Reference: **AW/223/25/TC**

Proposal: Lift crown to 2.5m above ground level and reduce crown to 10m in height and 7m in spread of
1no. *Eucalyptus* tree within the Aldwick Bay Conservation Area.

Location: 9 Tithe Barn Close, overhanging from 83 The Fairway, Aldwick

No. 1
Eucalyptus
Tree

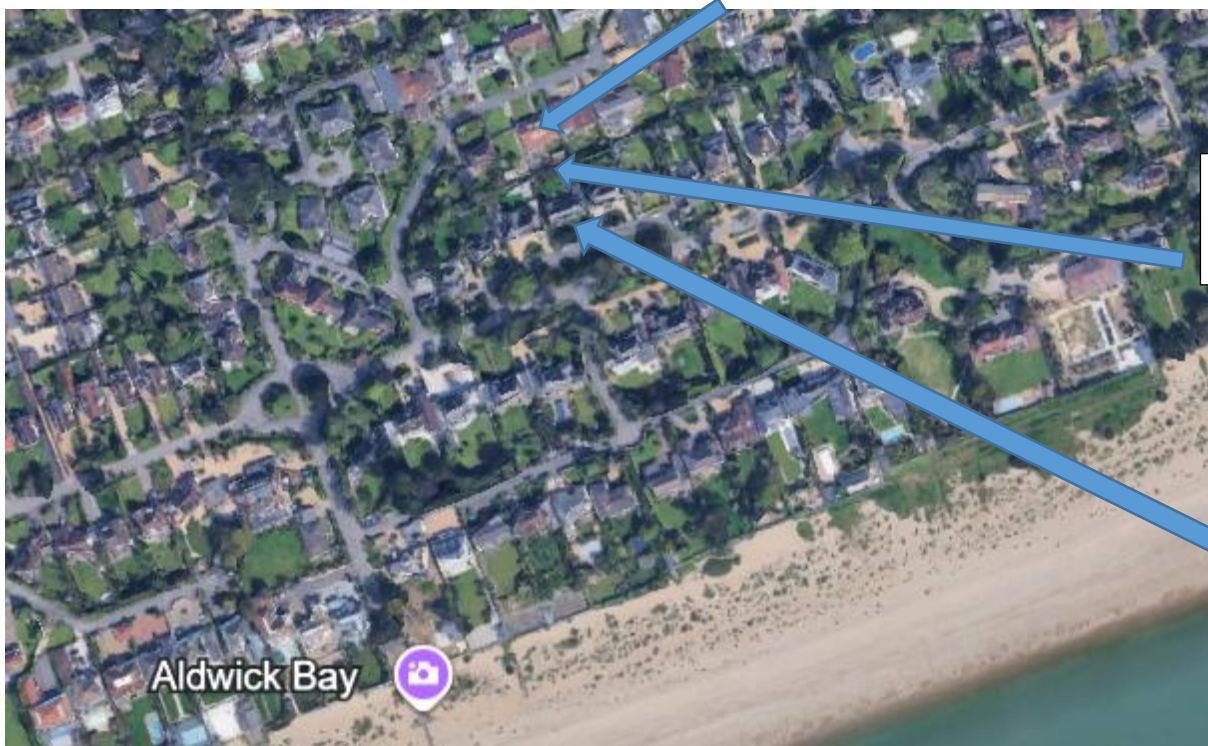
It is my understanding that the reduction in crown spread from 8 to 7metres is radial and applied to the north aspect of the tree only.
